ENG-PUDSP21005-R4-PDR-MDDP.pdf Markup Summary

**WATERBURY FILING NO. 1 & 2**  
GRADING AND EROSION CONTROL PLAN  
FINAL EROSION CONTROL PLAN 1

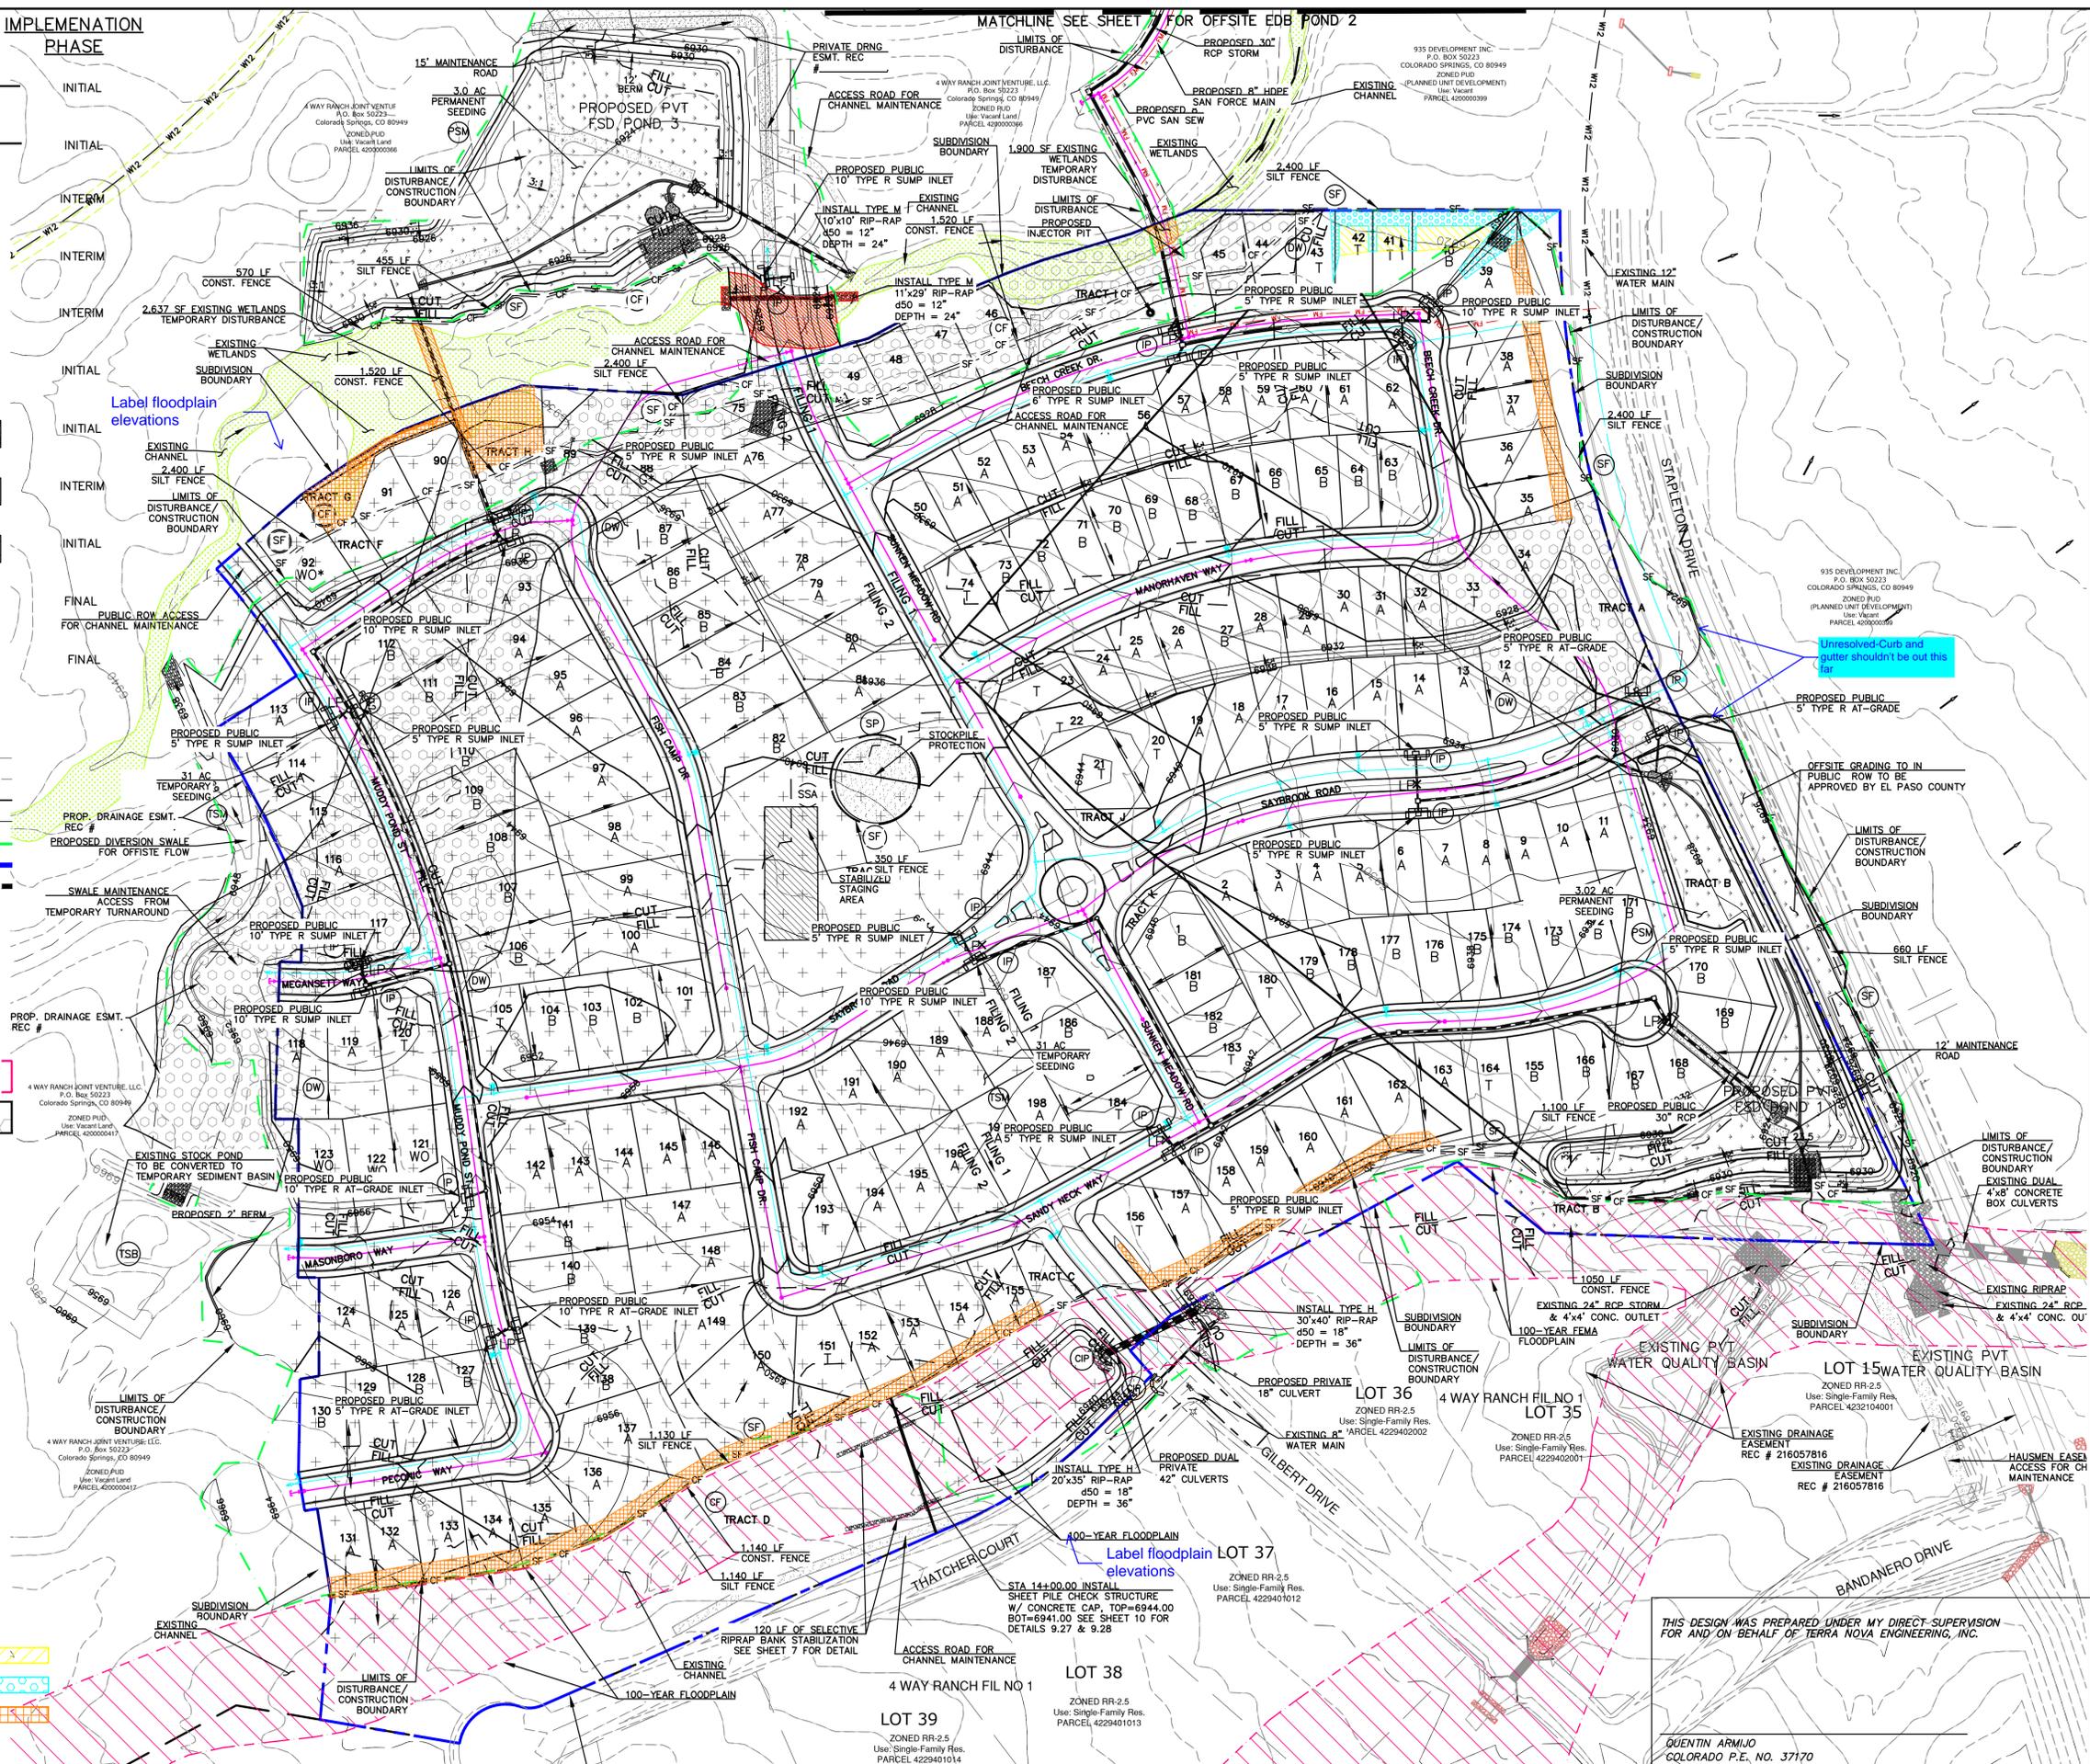
Per comments from a previous submittal, the SPA/RPA areas cannot include wetland areas per the MS4 Permit and MHFD guidelines.

Are these 2 yellow boxes supposed to be UIA's? Because pg 196 above shows the UIA for this sub-basin to be 0.

These areas are not shown as treated on the RR map or the Pond map. Create a separate color/hatching for excluded areas within the LOD and label which exclusion applies to each color/hatching type.

Plus the UIA overlaps with the RPA, which is not allowed.

Please define these SPA's. Are they excluded from needing WQ treatment? Reference the applicable ECM section for each exclusion type.

Some of these SPA's are outside of the LOD. None of the SPA's are provided WQ treatment, so why even show them on here?

removed, basin P from RR spreadsheet as it is all undeveloped pervious area that can be excluded

no they are no erased

done changed hatch and removed SPA label from legend and relabeled

it was left on by mistake now removed

changed hatch and removed SPA label from legend and relabeled as "EXCLUDED UNDEVELOPED PERVIOUS AREA"

added hatch to area outside of LOD
